**Project:** M1 Luton Airport DCO

**Stage** Deadline 9 (30<sup>th</sup> January 2024)

**Subject:** National Highways updated position on 'Accounting for Covid-19 in Transport Modelling'

**On Behalf of:** National Highways

Figure 9 – Luton Rising Proposed Upgrade to M1 junction10

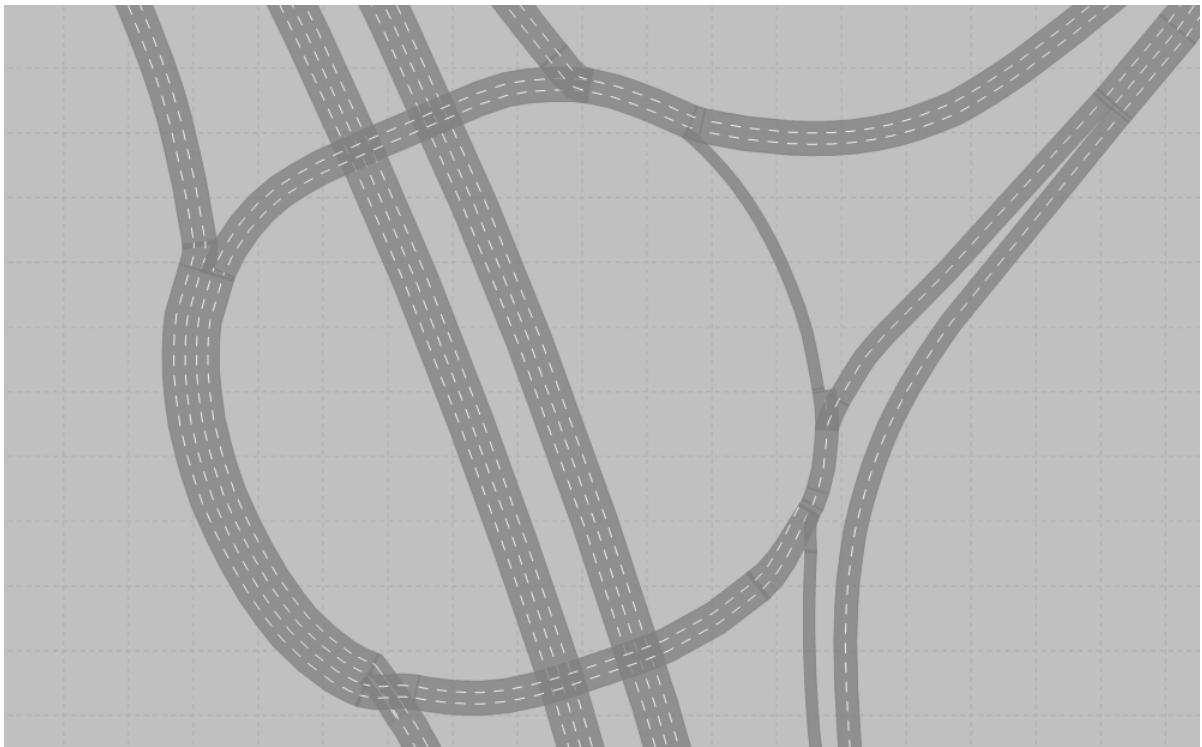
REP7-093, Ref 3.7 – VISSIM Model Outputs	The Applicant has provided a qualitative summary of model operation in the 2043 DM PM scenario. The Applicant’s position	NH disagrees with the Applicant’s assessment of the M1 northbound carriageway in the 2043 DM PM and considers that slow moving and

Issue/Reference	Luton Rising Response (Deadline 8)	National Highways (NH) Response (Deadline 9)
Part 3 – 2043 DM PM model operation	is that there is no notable congestion at the southbound merge at Junction 10 or northbound lane drop on the M1.	stationary vehicles are present in the modelling. In determining the application, this matter needs to be properly resolved.
REP7-093, Ref 3.7 – VISSIM Model Outputs Part 4 – 2043 DS PM	The Applicant response reaches similar conclusion to 2043 DM PM response above.	NH accept that the desired speed markers in this modelled scenario do not require further amendment. NH does not accept the Applicant’s position that the northbound lane drop has not significant impact on the operation of the M1 mainline.
REP7-093, Ref 3.4 - Conclusion	The Applicant provides a summary of the proposed highway mitigation measures. The applicant reiterates their position that these measures will adequately mitigate the SRN impact of the proposed development.	Based on analysis of the VISSIM models, NH considers that the proposed highway mitigation measures do not fully mitigate the impact of the proposed development on the SRN.  NH considers that there is a risk that the operation of the southbound merge at Junction 10 and the northbound lane drop on the M1 is worsened due to development traffic.

- The isolation of development trip impact (no future scenario without mitigation);
- The lack of journey time data for the assignment and convergence of the model; and
- The operation of the southbound merge at Junction 10 and the northbound lane drop on the M1 is worsened due to development traffic within the VISSIM forecast scenario as indicated by congestion at these locations in the VISSIM models.
